Recommendation Report for

REF NO: CM/5/18/PD

LOCATION: Church Farm
Church Lane
Climping
BN17 5RB

PROPOSAL: Prior approval under Class R for the proposed change of use of agricultural building to B8 Storage or Distribution.

Location and Access plan

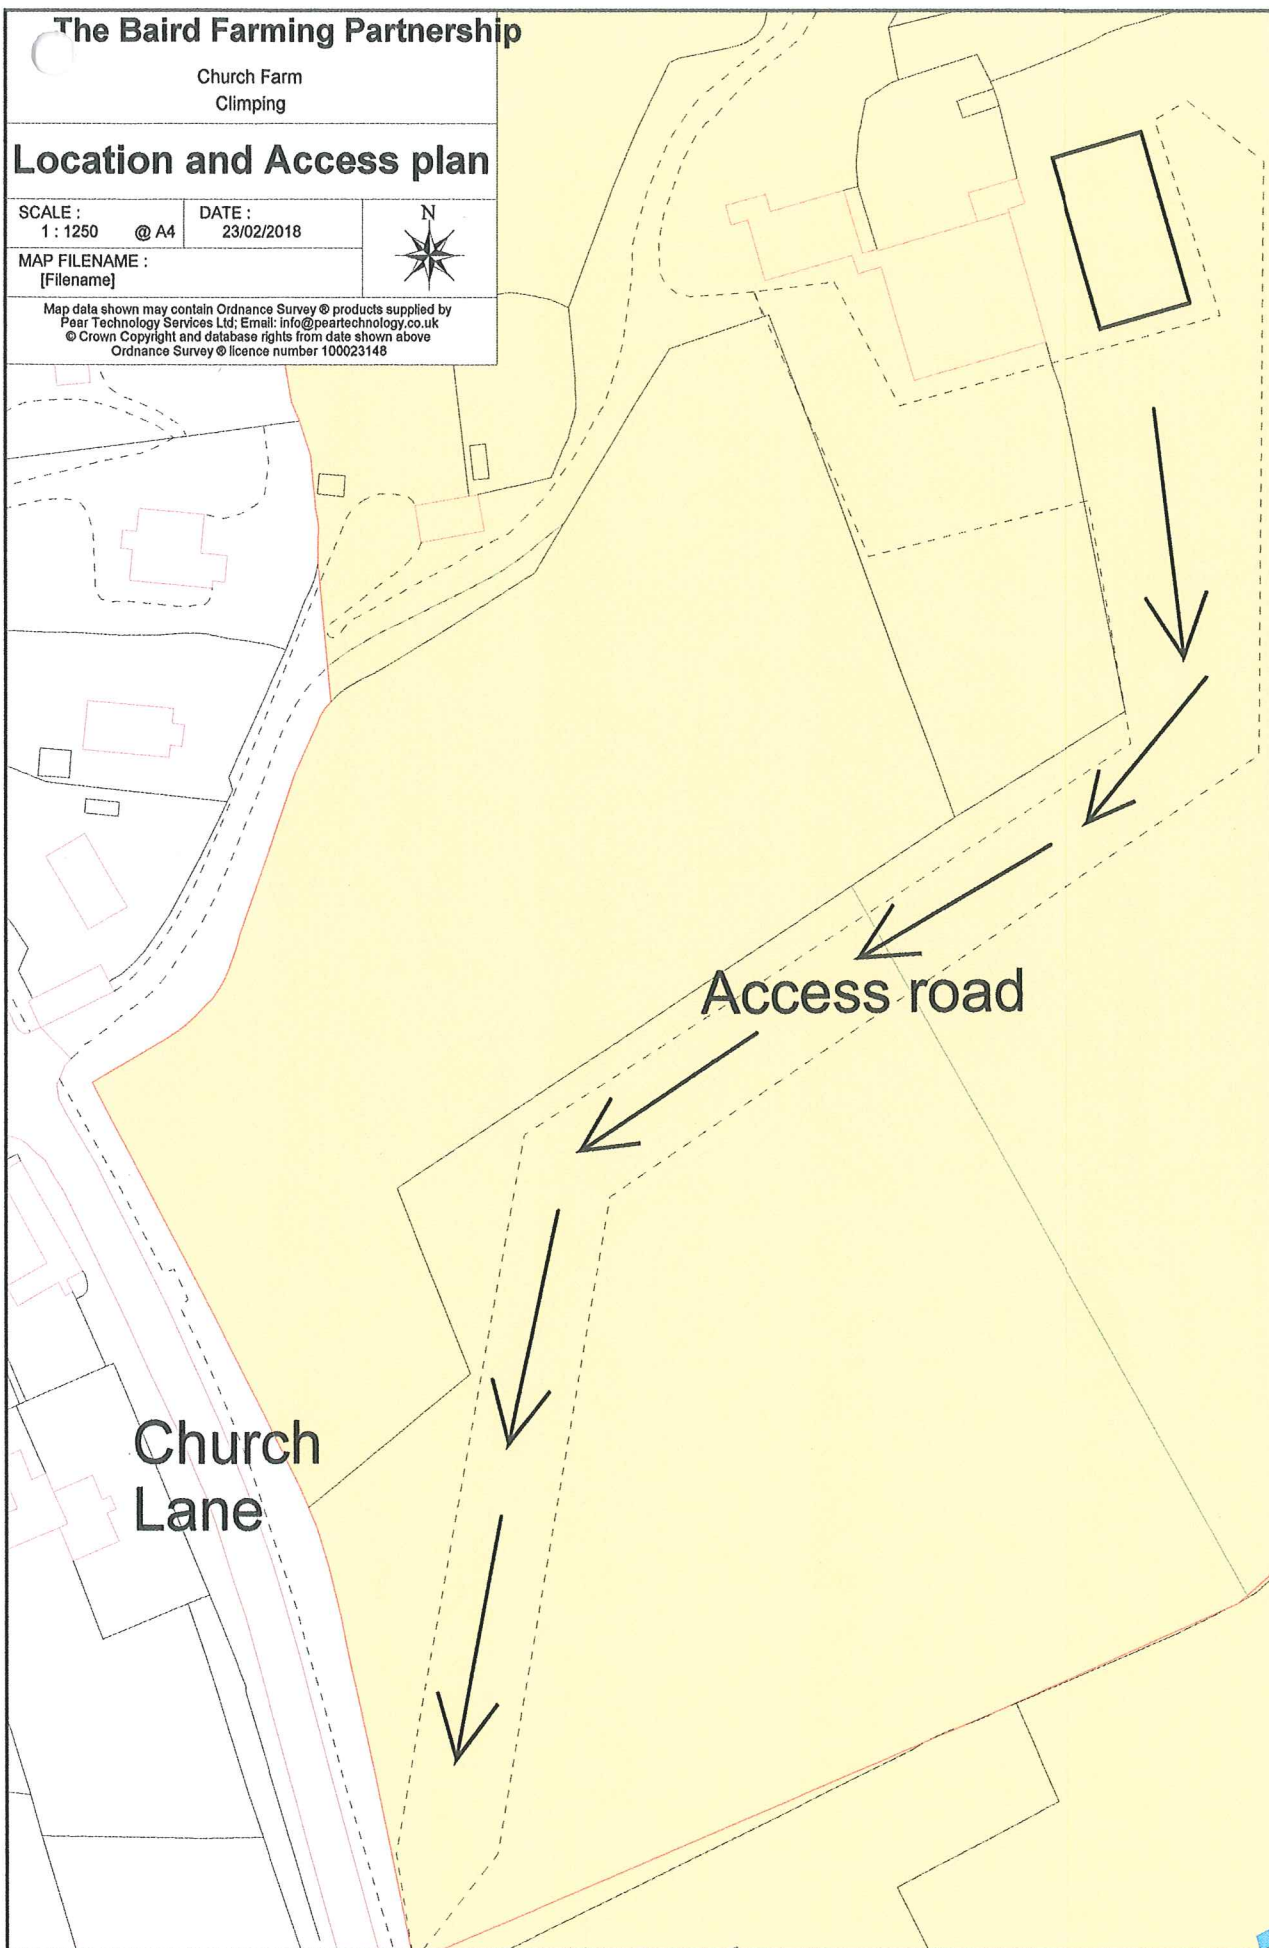
The existing access has clearly been designed for farm/large vehicle and is of sufficient width for a large vehicle to access from the south. However, given the angle of the access, larger vehicles may have difficulties accessing and exiting the site when approaching from the north. This issue may not have been problematic for low levels of traffic, for articulated farm vehicles or for vehicles approaching from the south, however it is a concern due to possible intensification in use in relation to the proposed change of use. A plan showing the swept path for a large HGV entering and exiting the site access is required.

No parking spaces have been shown on the plans. In accordance with WSCC parking standards a total of 15 car parking and 2 lorry parking spaces are required for 500sqm of B8 Storage and Distribution use.

- The bell mouth entrance is 16 metres wide at its widest point.
 - The entrance gates are set back 22 metres from the highway allowing the largest HGV's to safely wait off the highway if they arrive and the gates are locked.

- The entrance is 8 metres wide at its narrowest point, which has proven to be more than sufficient for 2 large HGV vehicles to pass each other, should the need arise.

It is not considered that conditions relating to a Construction Management Plan or wheel washing are required. The building is existing. The wording of the suggested parking condition has been amended to relate to submission of details of parking.
